From: [Jason Adams](#)
To: [Zach Torrance-Smith](#)
Cc: [Justin Turnbull](#)
Subject: Re: SX-23-00017
Date: Thursday, September 21, 2023 6:24:48 AM
Attachments: [Response Letter.pdf](#)

The entire scope of this permit revision is specifically-

Excavate 2 - (36" square holes) and pour footings and columns to grade. From there build the deck. The septic, power, gas, and water are all complete and existing as is the small shop that was the original permit.

SITE PLAN

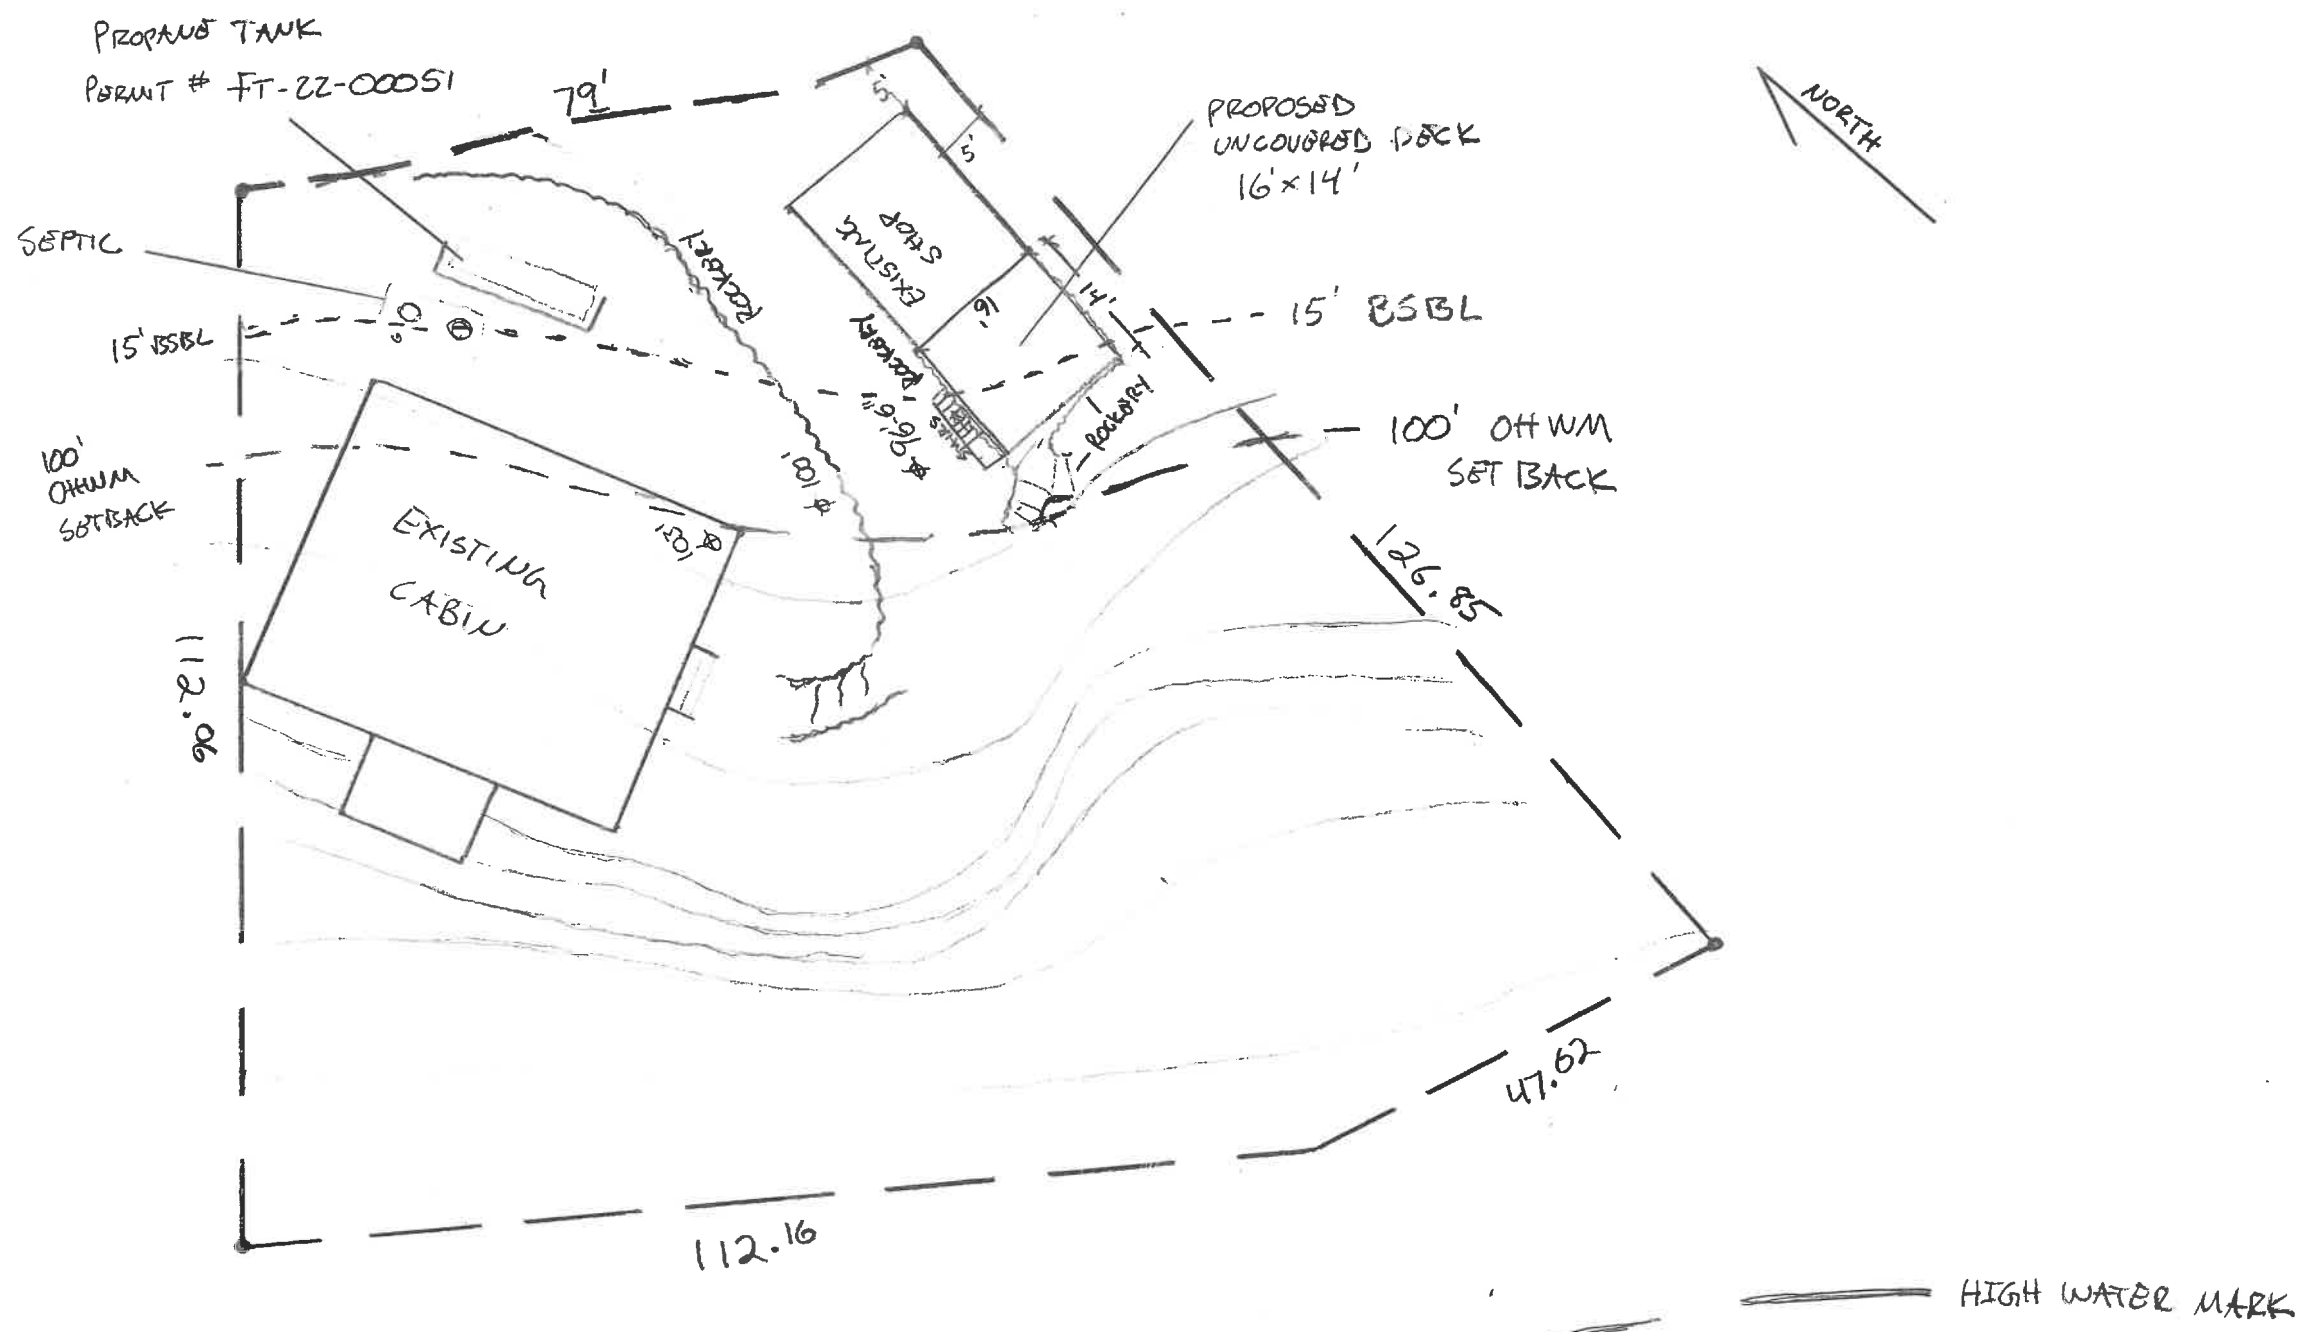
I'm including our County Surveyor Justin Turnbull to help clarify what is needed to satisfy the Survey comments. Please note the Shoreline Exemption Permitting application form states the following:

“Required Information/Attachments: A scaled site plan is required showing **location of all** structures (including decks), driveways/impervious surfaces, well, septic, propane tanks, fences, etc. and proposed uses and distances from property lines, river, and horizontal distance from Ordinary High Water Mark. To show the horizontal distance a profile view from the OHWM to the edge of structure/activity shall also be shown.”

per survey's comments - I am not clear on what was provided on the site plan, is it the well specifically. Said well is not on our property, I showed the driveway, septic, all structures etc?

Could I please get specifics on what survey is deeming incomplete on the site plan pertaining specifically to the associated scope of work?
